ADDENDUM 4
To Contract Documents for
EYECARE MEDICAL GROUP
53 SEWALL STREET
PORTLAND, ME 04102

E.M.G. - Phase 2 Addition & Renovation

EYECARE MEDICAL GROUP
PHASE 2 ADDITION AND RENOVATION
ADDENDUM NO. 4
JULY 29, 2013

SHEET  
**E000**

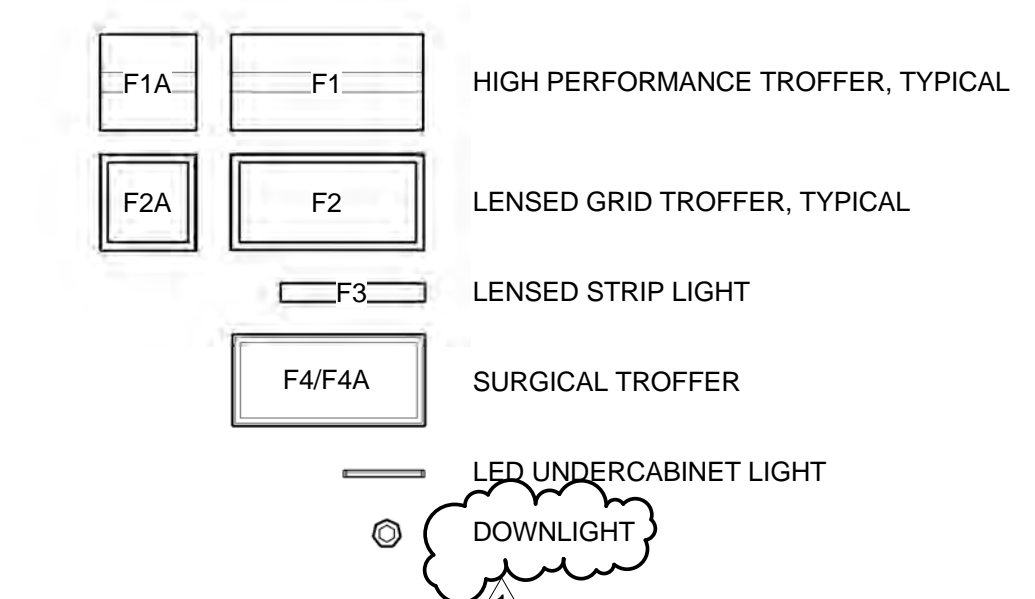
1. Sheet E000: Refer to Sketch SKE-4, attached for revisions to the electrical legend.
2. Sheet EPI01: ADD a ceiling mounted wireless access terminal outlet in each room for rooms Post Op BI09, OR N04 BI17, OR N03 BI20, and the existing Pre Op Room.

Drawing file: 1. Original Plans / PL102 PLUMBING DOMESTIC PIPING PLAN.pdf

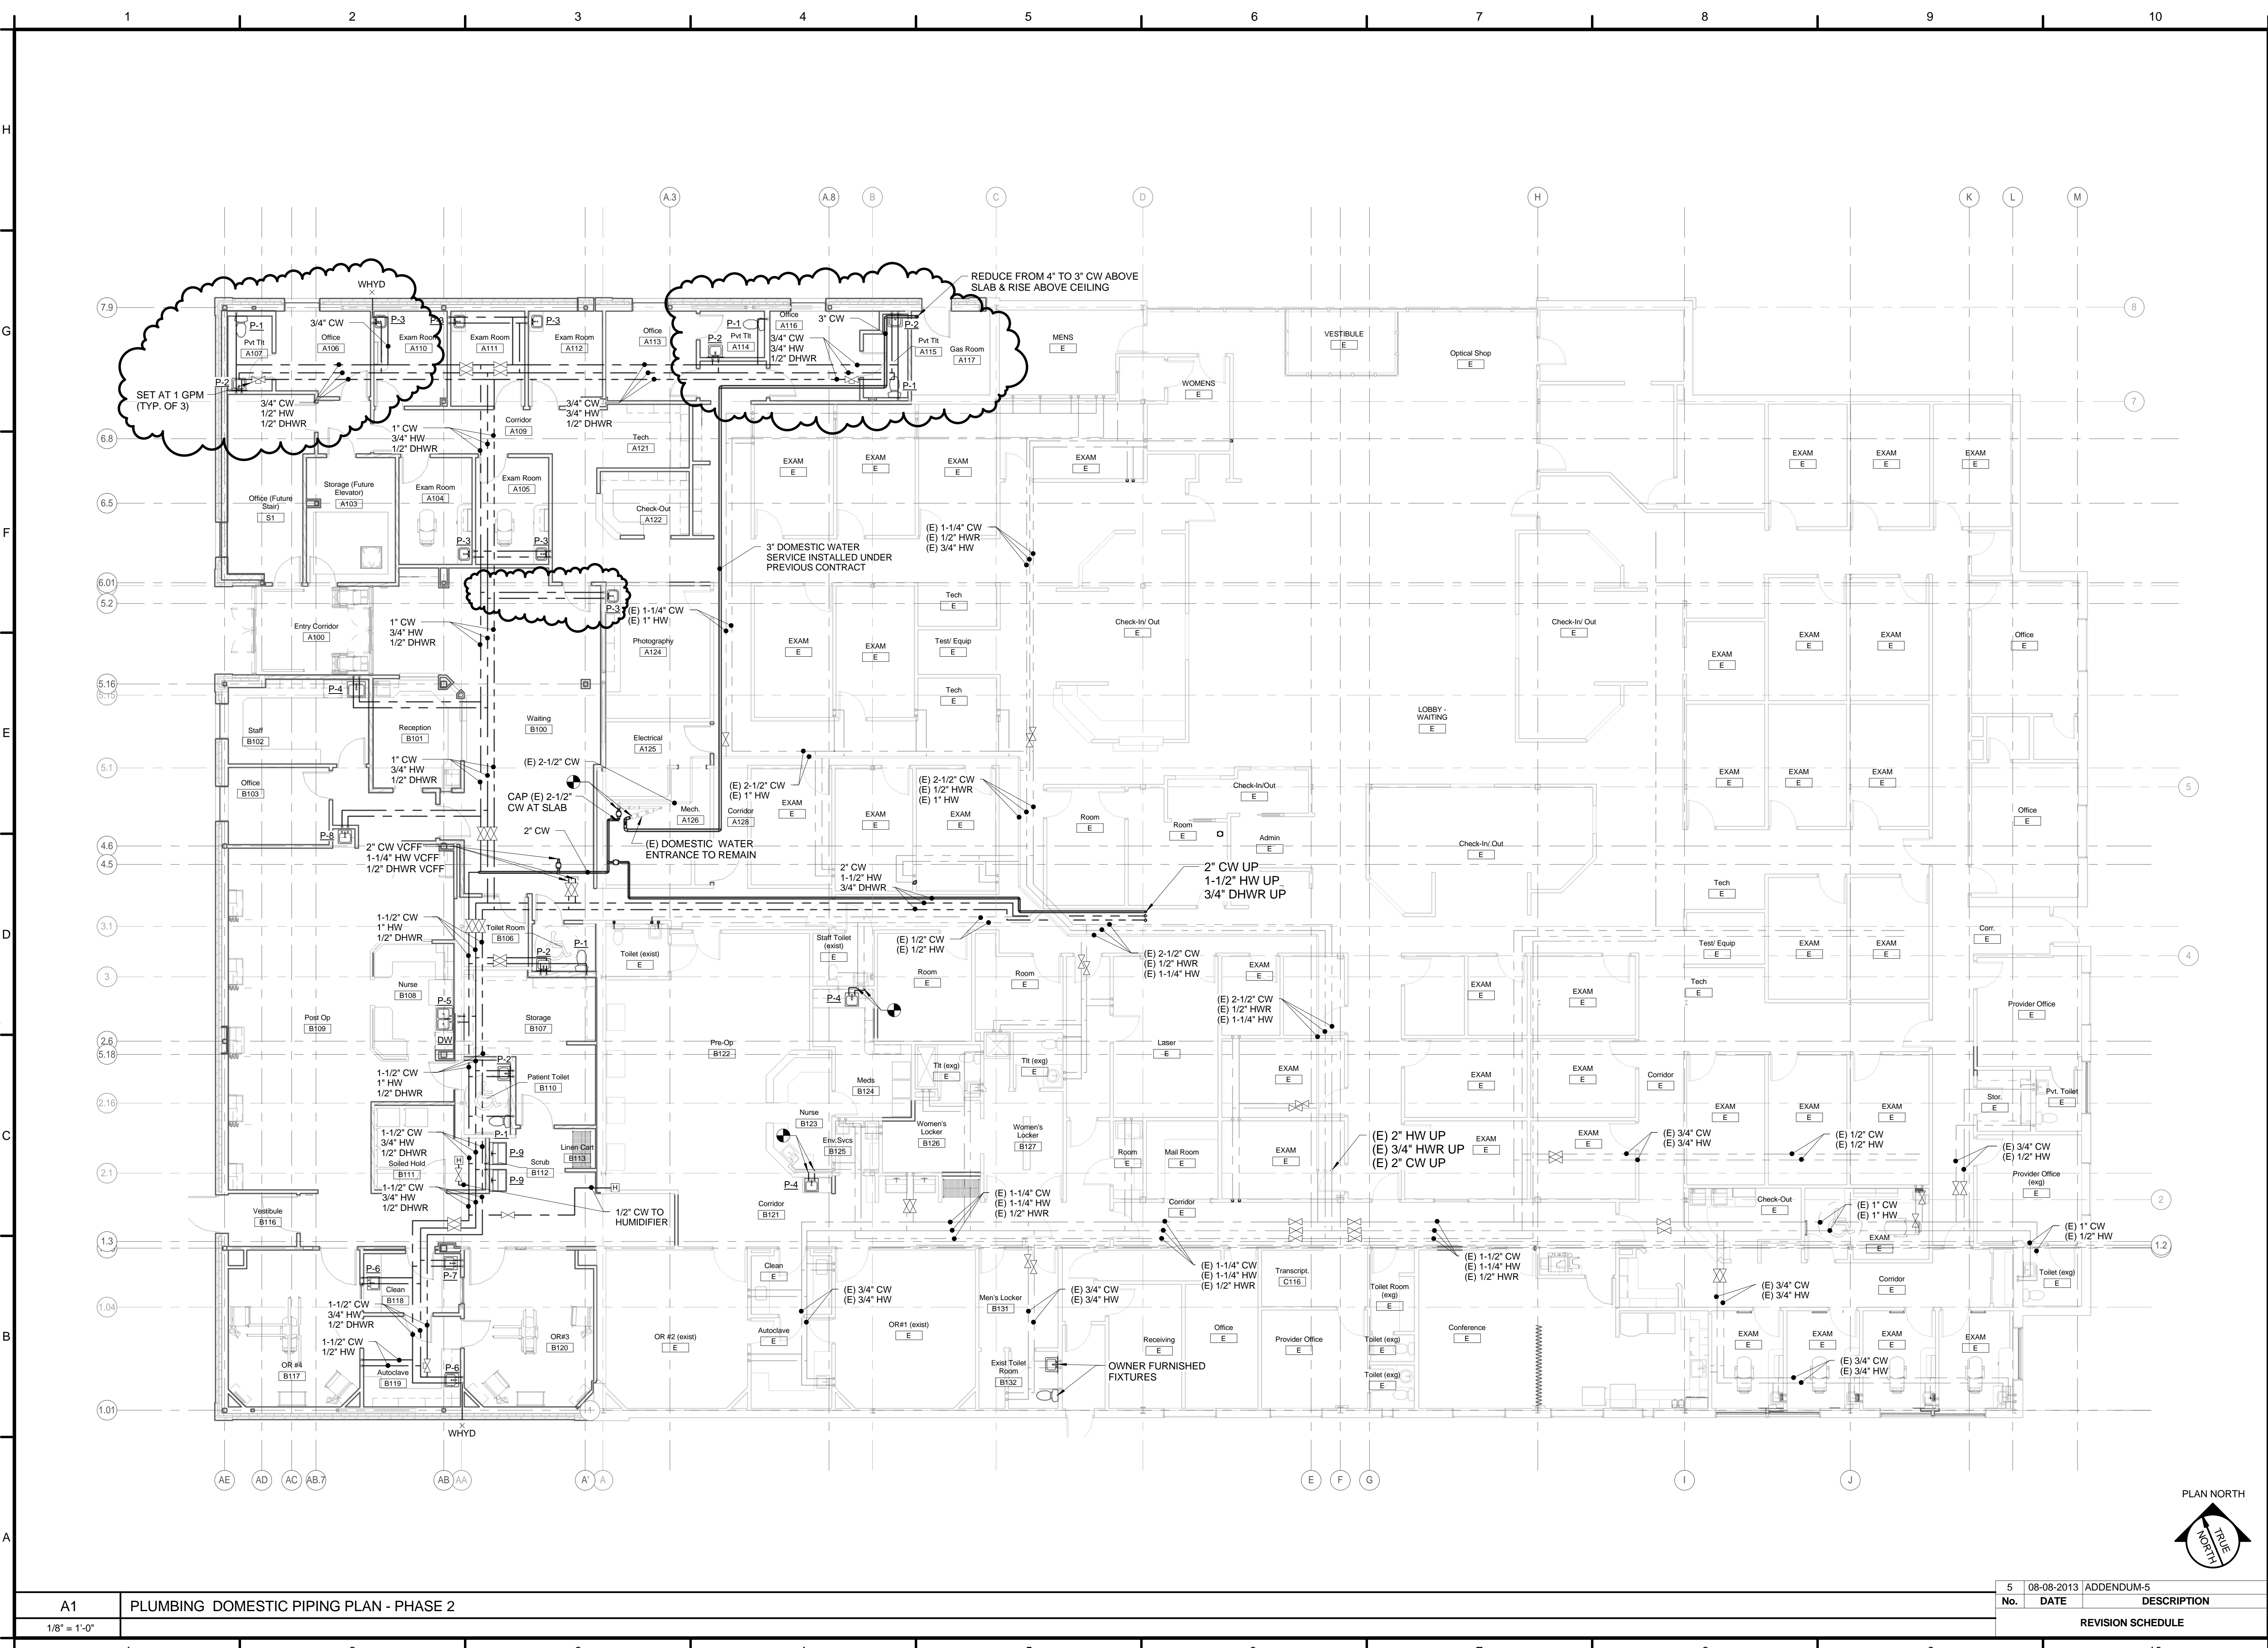
- I. Sheet PL-102: Refer to SKP-7, attached for revisions to the domestic water piping.
